Your Ref: P/132/20/RES

Our Ref: LM/ARU/21/01A

RE: Land north of Hook Lane Pagham

Thank you for your correspondence of the 8th of January 2021, advising me of a planning application for Approval of reserved matters following P/30/19/OUT for 300 No. new homes, internal roads, footpaths & cycleways, car parking & landscaping. This application affects the setting of a listed building & falls within Strategic Site H SP2, CIL Zone 1 (Zero Rated) at the above location, for which you seek advice from a crime prevention viewpoint.

Project	Hook Lane, Pagham
Drawing	Site Layout
Client	Hallam Land
Job no.	HALL200505
Dwg no.	SL01
Author	AS
Status	PLANNING
Client ref.	
Date	June 2020
Revision	A
Scale	1:1000 at A1
Office	Romsey

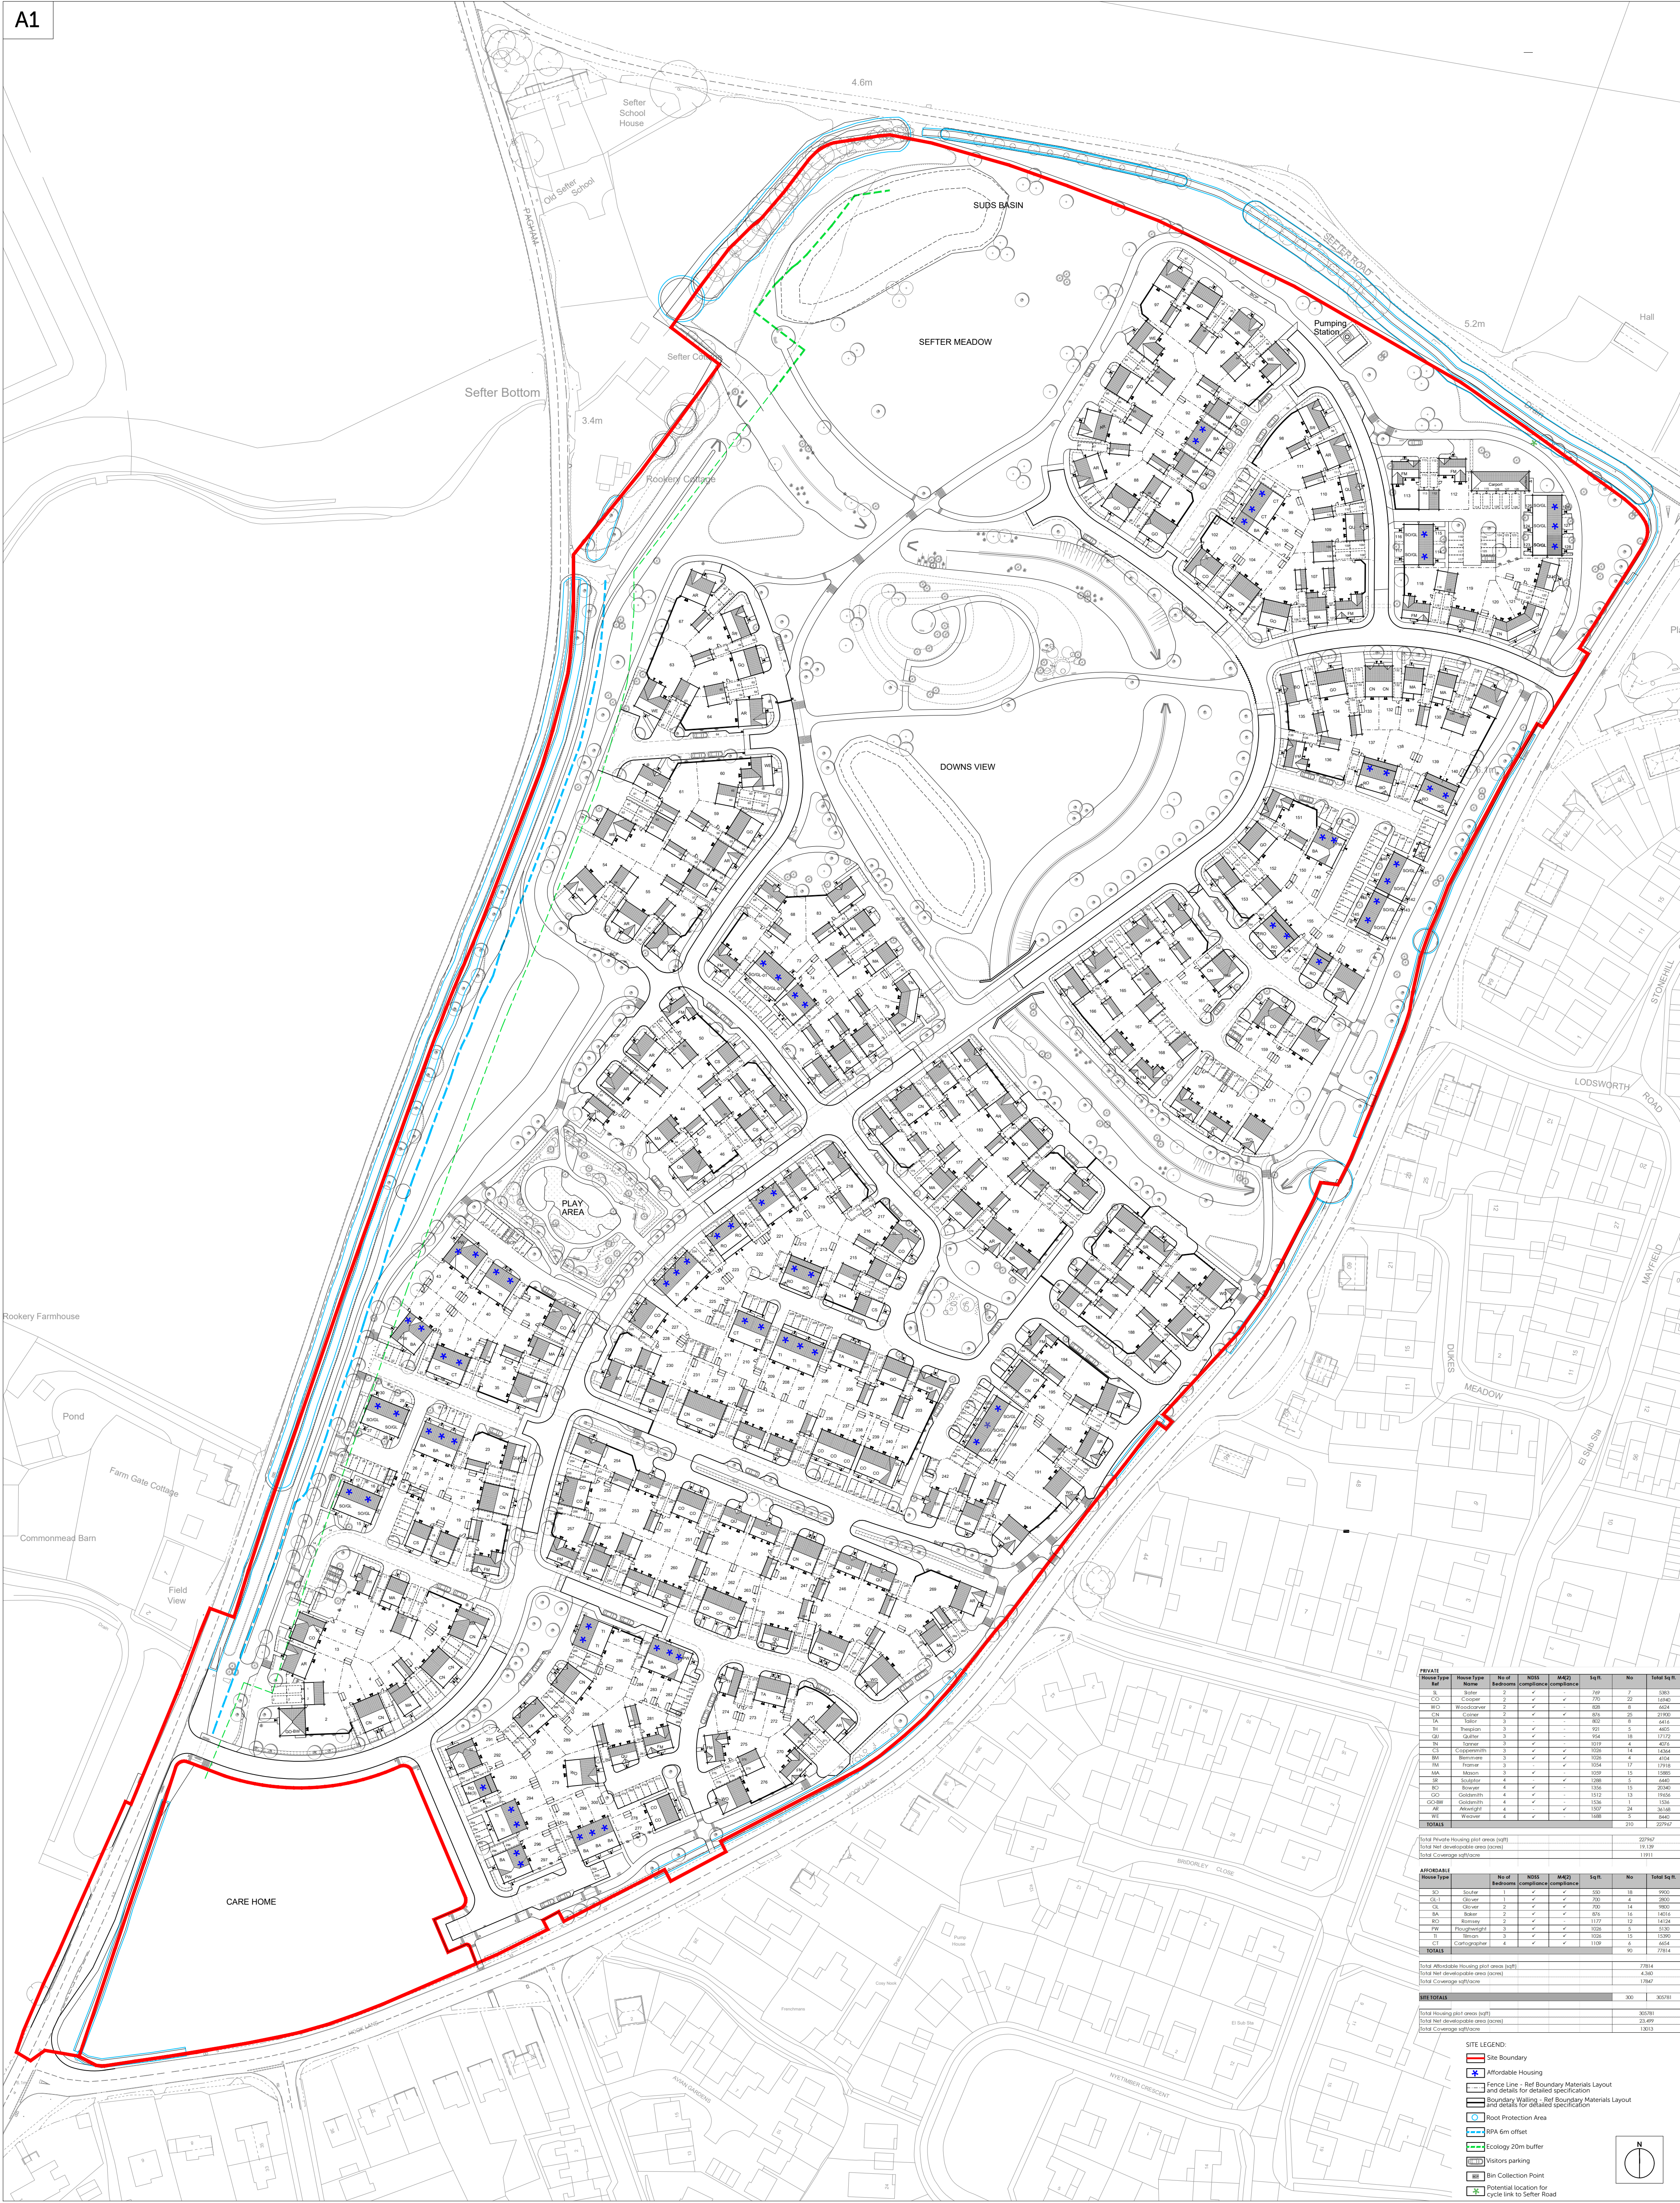
I was pleased to note that the orientation of the dwellings will ensure that all publicly accessible areas including the road layout and communal amenity space benefit from overlooking and good natural surveillance. Where communal parking occurs it is important that they must be within view of an active room within the property. An active room is where there is direct and visual connection between the room and the street or the car parking area. Such visual connections can be expected from rooms such as kitchens and living rooms, but not from bedrooms and bathrooms.

With regards to the area of play - I refer the applicant to Chapter 9 SBD Homes Version 2 2019. I would ask that consideration is given to surrounding the area of play with railings with self-closing gates to provide a dog free environment.

With regards to the cycle/footpath I direct the applicant to SBD Homes 2019 Version 2 which states that: Footpath design 8.8 Routes for pedestrians, cyclists and vehicles should be integrated and assist easy, intuitive wayfinding through the application of inclusive design by increasing activity and therefore natural surveillance, a proven deterrent to crime and anti-social behaviour. 8.9 Public footpaths should not run to the rear of, and provide access to gardens, rear yards or dwellings as these have been proven to generate crime. 8.10 Where a segregated footpath is unavoidable, for example a public right of way, an ancient field path or heritage route, designers should consider making the footpath a focus of the development and ensure that they are: • as straight as possible; • wide; • well lit (see paragraphs 8.19 to 8.21); • devoid of potential hiding places; • overlooked by surrounding buildings and activities; • well maintained so as to enable natural surveillance along the path and its borders.

Additionally 8.17 states where footpaths run next to buildings or roads, the path should be open to view. This does not prevent planting, but will influence the choice of species and the density of planting. Public footpaths should not run immediately next to doors and windows, therefore defensive space should be created to separate a path from a building elevation. 8.19 suggests If a footpath is to be used 24 hours a day it should have all the required attributes as listed at paragraph 8.10 and be lit in accordance with BS 5489-1:2013. If the footpath does not have these attributes then its use should be deterred during the hours of darkness by not installing lighting.

With regards to the proposed landscaping - careful selection of plant species is critical in order not to impede natural surveillance and avoid unnecessary high maintenance. Trees on appropriate route stocks can provide a more reliable means of reducing the likelihood of reducing natural surveillance. Trees may restrict the performance of street lighting or cause damage by collision with branches and should not be located within 5 metres of a light source. Account must be taken of the effects of seasonal variations.

As a general recommendation where good visibility is needed shrubs should be selected to have a mature growth height no higher than 1 metre, and trees should have no foliage or lower branches below 2 metres which allows 1 metre field of view between them.

Finally, lighting throughout the development will be an important consideration and where it is implemented it should conform to recommendations within BS 5489-1:2013 SBD considers that bollard lighting is not appropriate as it does not project sufficient light at the right height making it difficult to recognise facial features and as a result causes an increase in the fear of crime.
